From: Cleaver, Elizabeth <Elizabeth.Cleaver@nationalhighways.co.uk>
Sent: 27 June 2022 18:01
To: [REDACTED]
Cc: Simon Davis; Planning SE; Bowie, David
Subject: National Highways response: Y/3/22/OUT, Land West of Bilsham Road, Yapton
Attachments: A27 YAPTON LANE ITB11324-GA-014 Rev C.pdf

For attention of:	Mr Thomas Moloney
Site:	Land West of Bilsham Road, Yapton
Proposal:	Hybrid Application comprising of: Outline planning application for further phases of up to 110 No dwellings and associated infrastructure (with all matters reserved) and Full application for Phase 1 for 30 No residential dwellings, new access from Bilsham Road, public open space, landscaping, sustainable urban drainage and associated works. This application is a Departure from the Development Plan and is in CIL Zone and is CIL Liable as new dwellings.
Your Reference:	Y/3/22/OUT
National Highways' Ref:	HAMIS 93768; Tracker #17048; (JSJV SB379)

Appendix C – A27 Mitigation Scheme

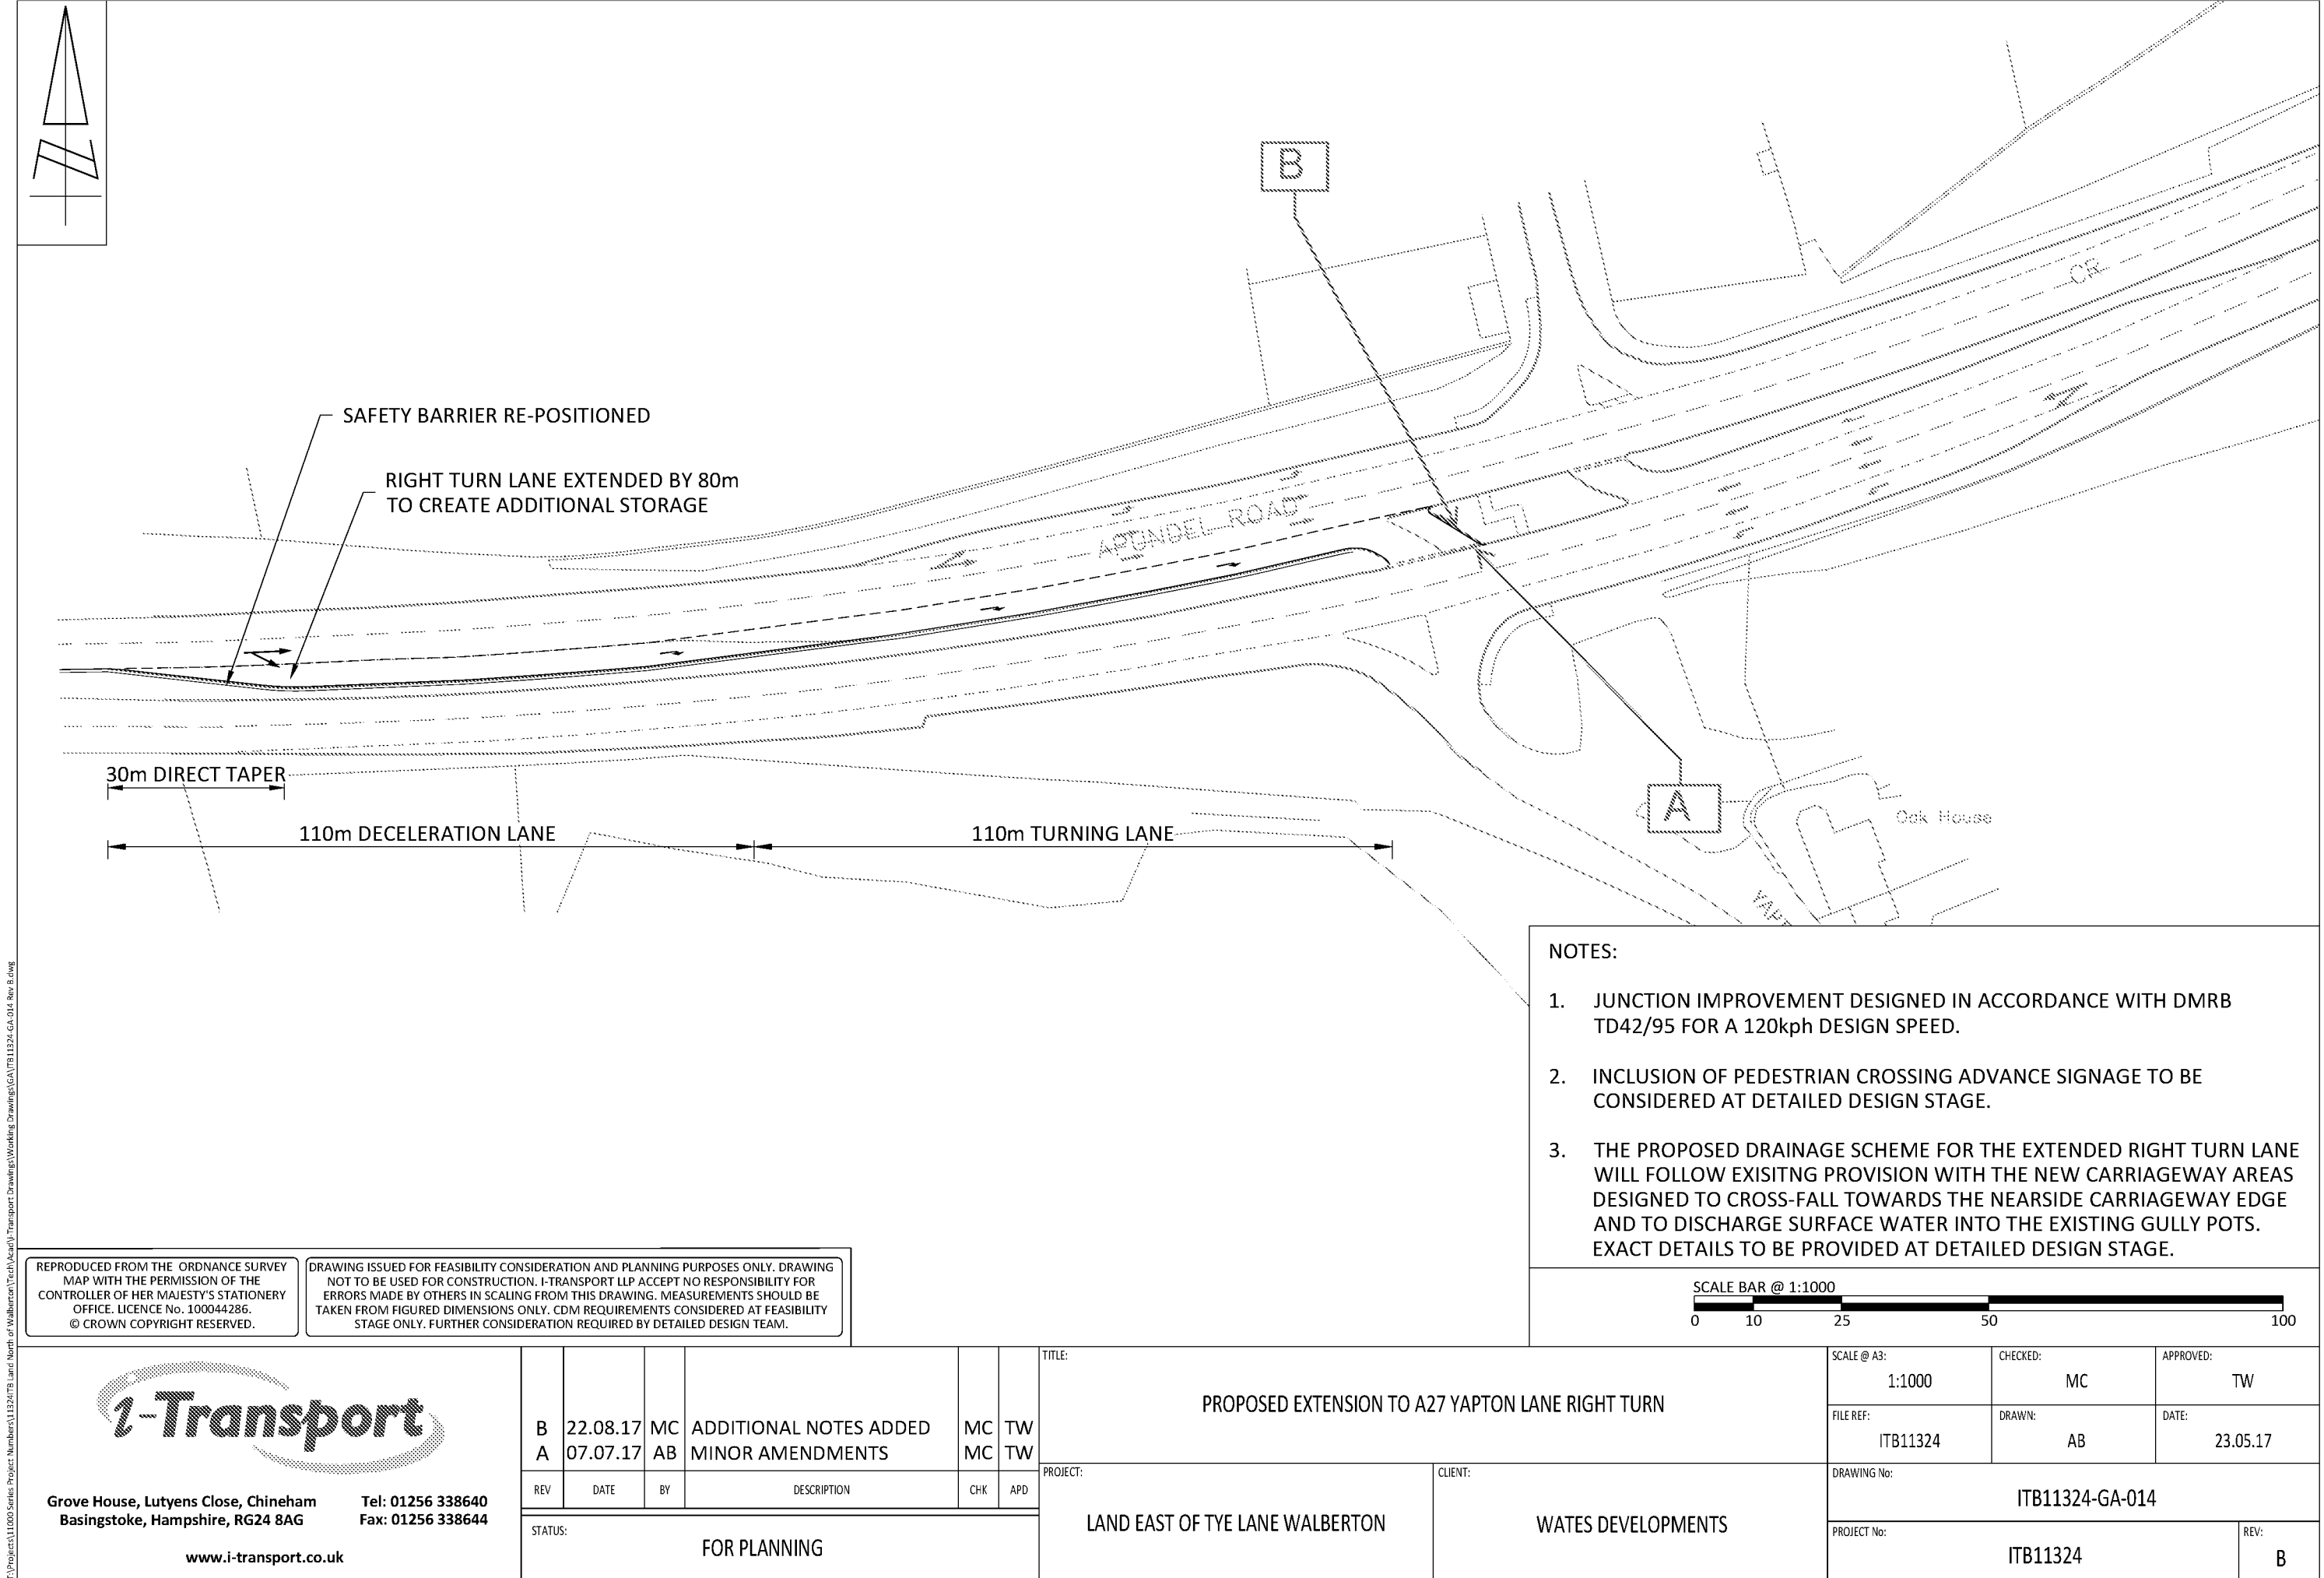
As per previous correspondence, there is a committed mitigation scheme for the A27/Yapton Lane junction, as shown on drawing number ITB11324-GA-014 Revision C (attached). Once the junction modelling has been updated considering the above actions, the results will inform our decision on whether any further mitigation is required as per our previous stance.

A further modelling exercise needs to be undertaken for the 2024 and 2031 scenarios with the model layout adjusted to reflect the committed improvement scheme. This should include the statistical analysis of queue length data as described above.

ACTION: The future year model scenarios should be re-tested with an updated layout to reflect the committed improvement scheme (shown on drawing ITB11324-GA-014 Revision C). The tests should include analysis of the detailed queue data in a similar manner to that described for the current models.
